**Reference: 437 Donald B. Munro Drive  
Rail Safety Review  
Our File Number: 119023**

This letter provides a review of railway safety issues as it relates to the planned commercial and residential development at 437 Donald B. Monroe by Maple Leaf Custom Homes.

CITY OF OTTAWA 437 - DONALD B. MUNRO DRIVE		PROJECT NO. 119023
GRADING AND DRAINAGE PLAN		REV REV # 1
		DRAWING NO. 119023-GR

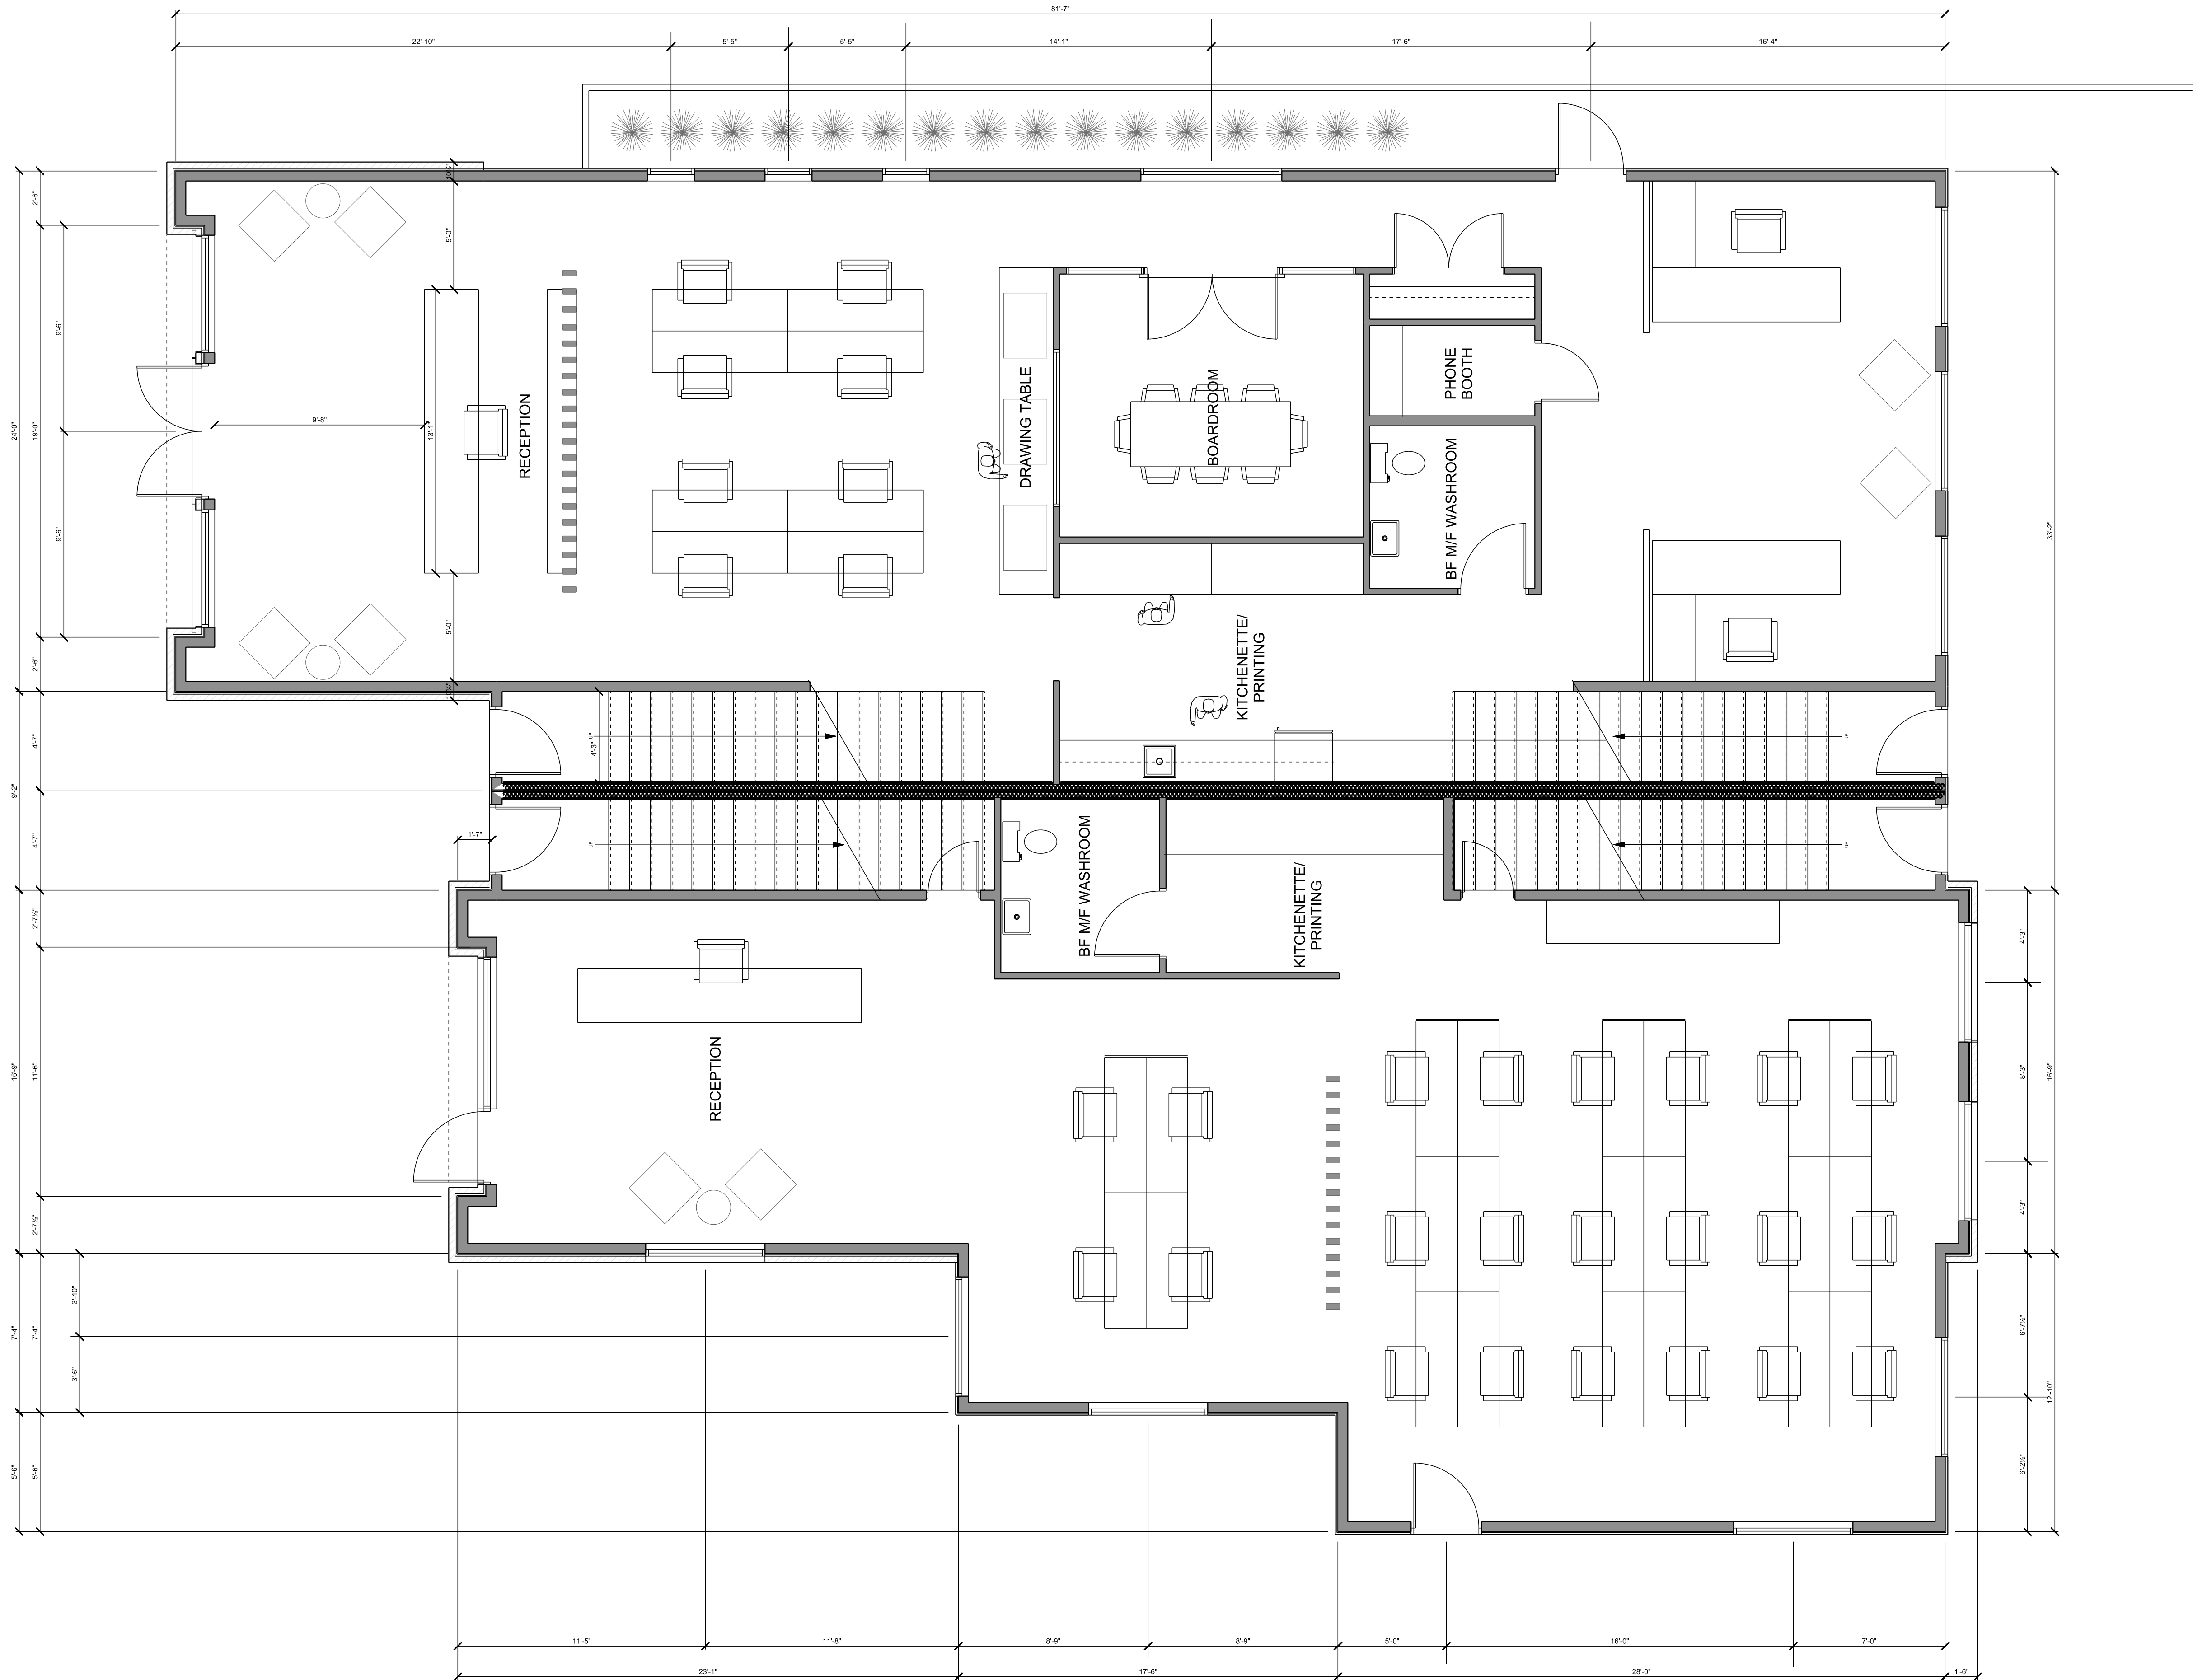
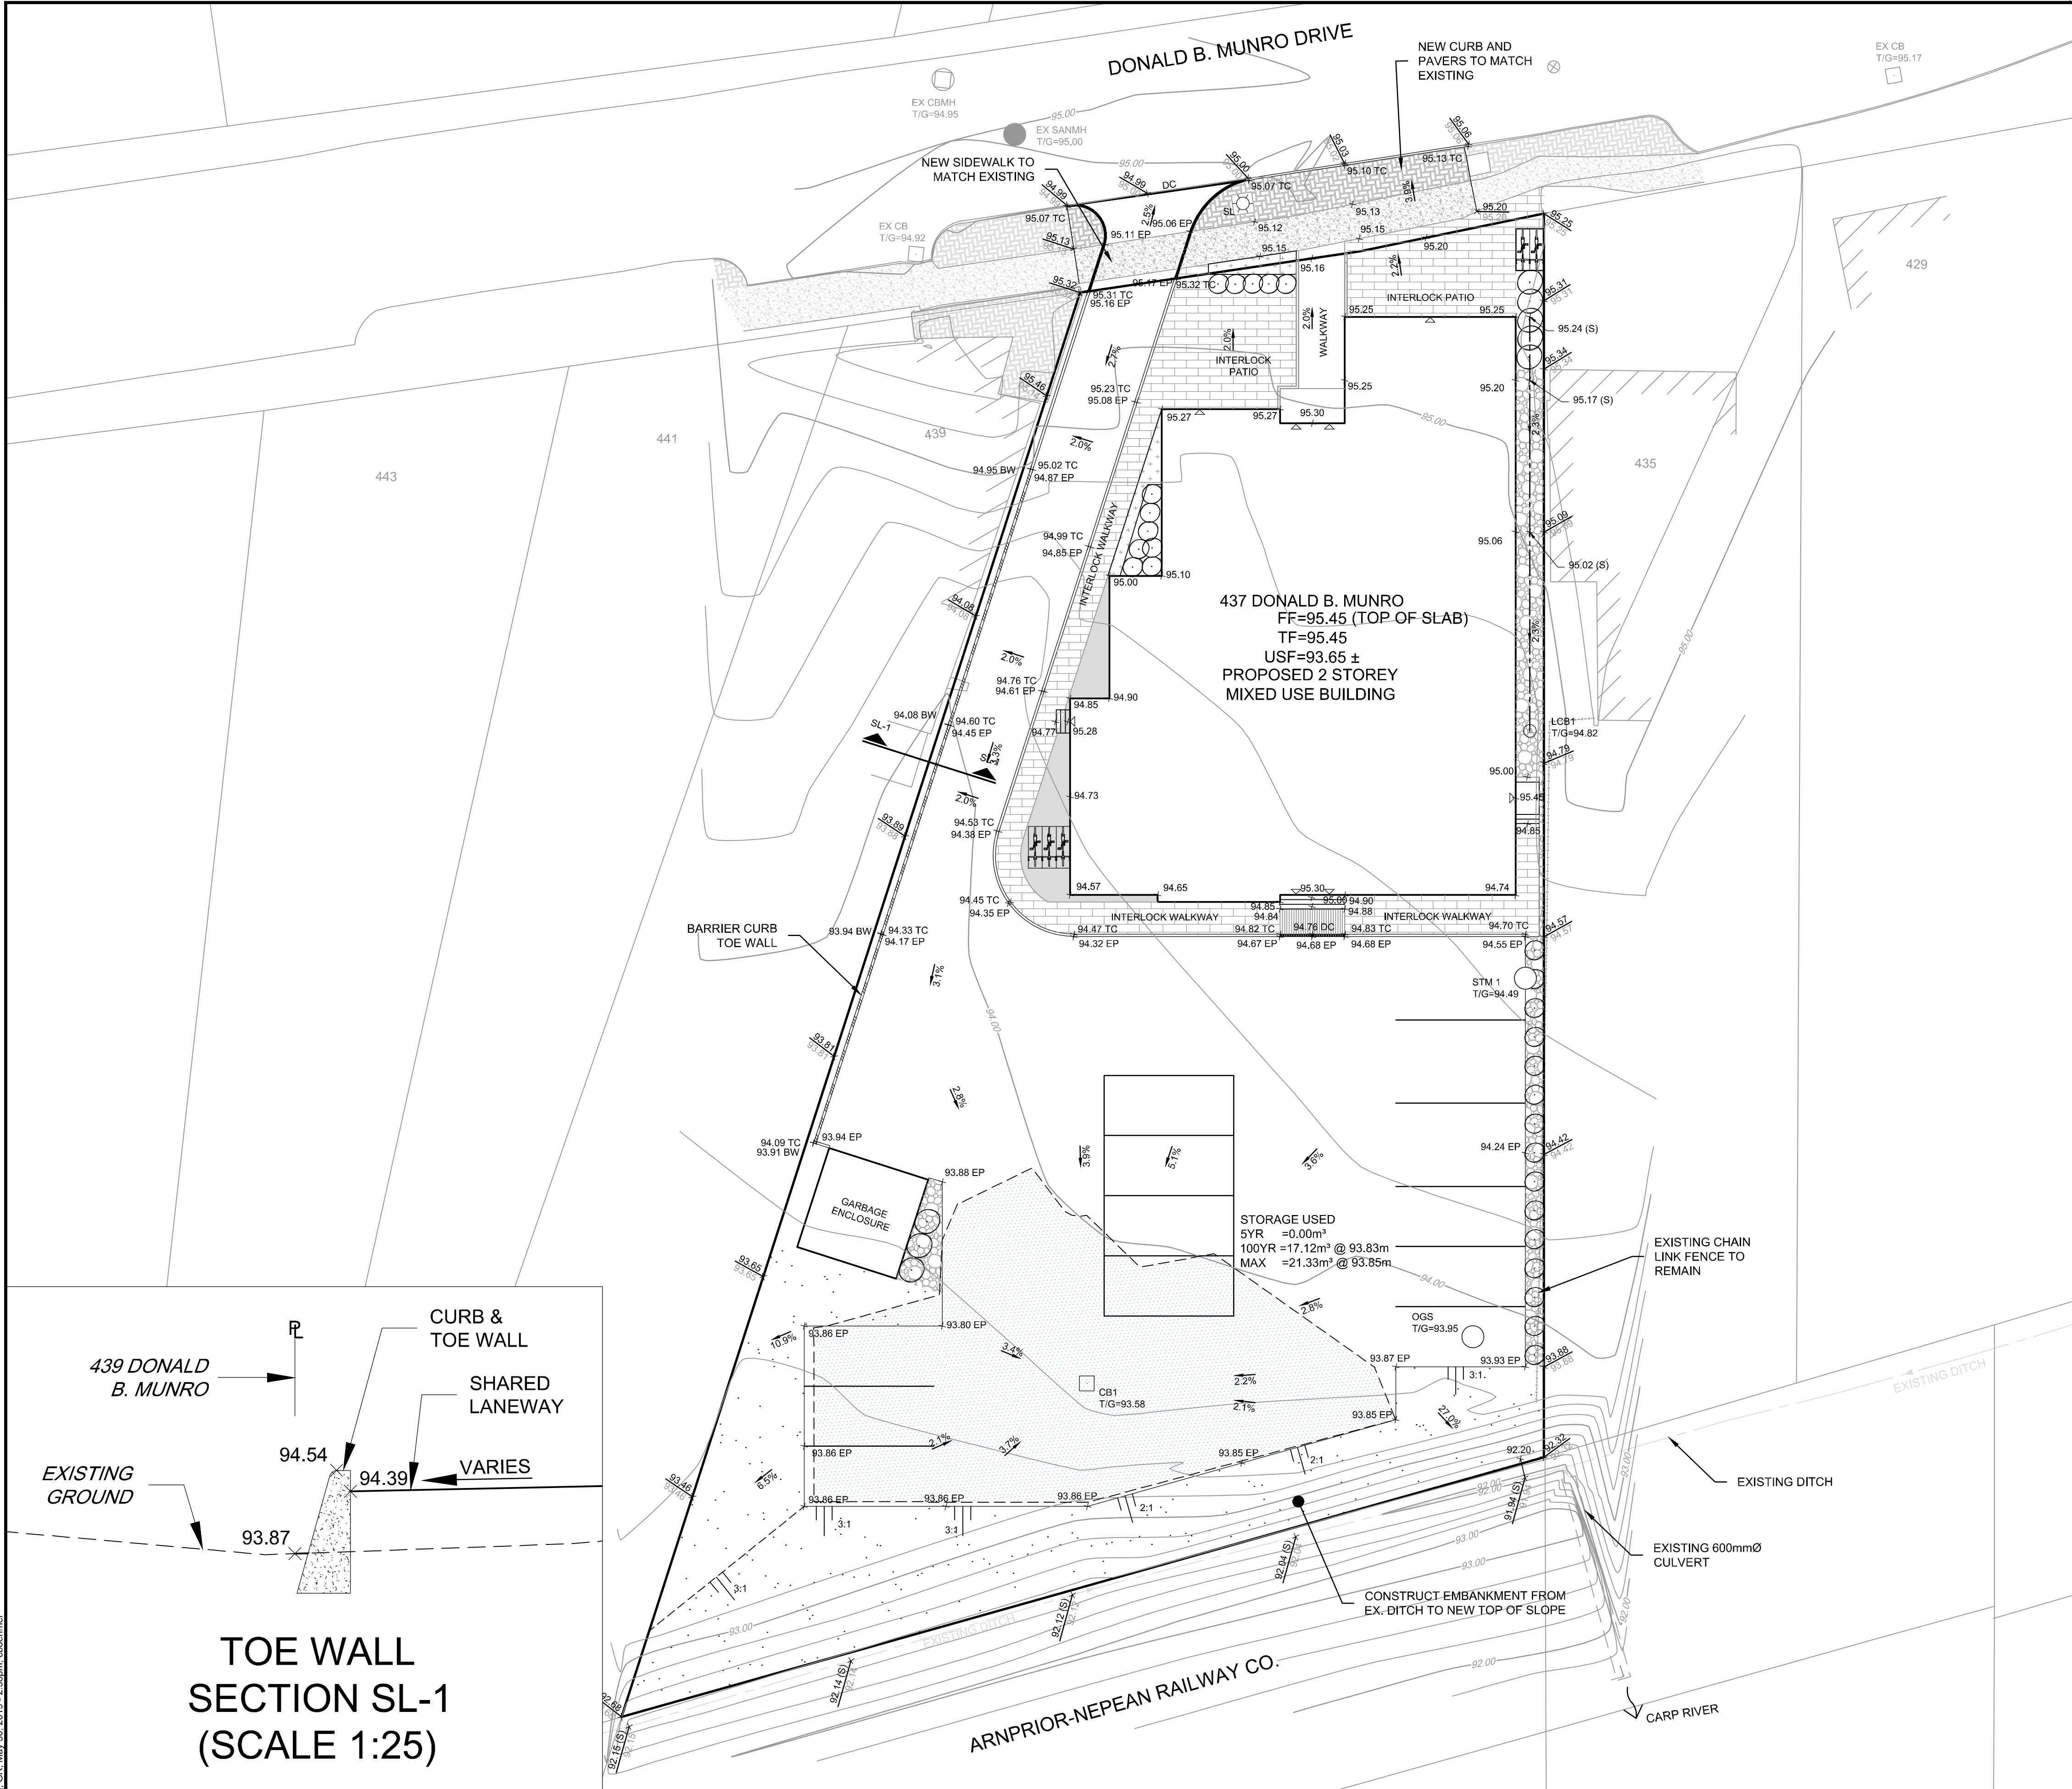
There is an existing ditch embankment that runs parallel to the railway corridor with side slopes of 30%-60% with the ditch located 0.25m-0.75m off the property line. The Grading Plan depicts a berm with side slopes of 2:1 at the closest driving isle that transitions to 3:1 near the east and west property lines. The proposed berm

height varies from 1.72m-2.00m measured from the bottom of ditch, or from 1.60m-1.64m if measured from the property line.

While close, the safety barrier proposed on the Grading Plan dated May 31, 2019 does not comply with the standard guidelines for height or side slope. That said, the guidelines do permit reduced berm height where larger setbacks are proposed; similarly, increased berm slopes are considered in tight situations. We recommend the developer contact the railway authority to explore permissible design solutions and obtain clearance.

- Confirm the railway traffic information outlined above is current (trains, cars, speed, frequency, etc.)
- Confirm the designation as a Principal Branch Line with the railway authority (ARNCI)
- Obtain railway authority concurrence on the safety berm high requirements for this development
- Obtain railway authority concurrence on maximum acceptable safety berm side slopes for this site
- Propose security fencing between the railway and private property
- Update the design plans and resubmit for approval
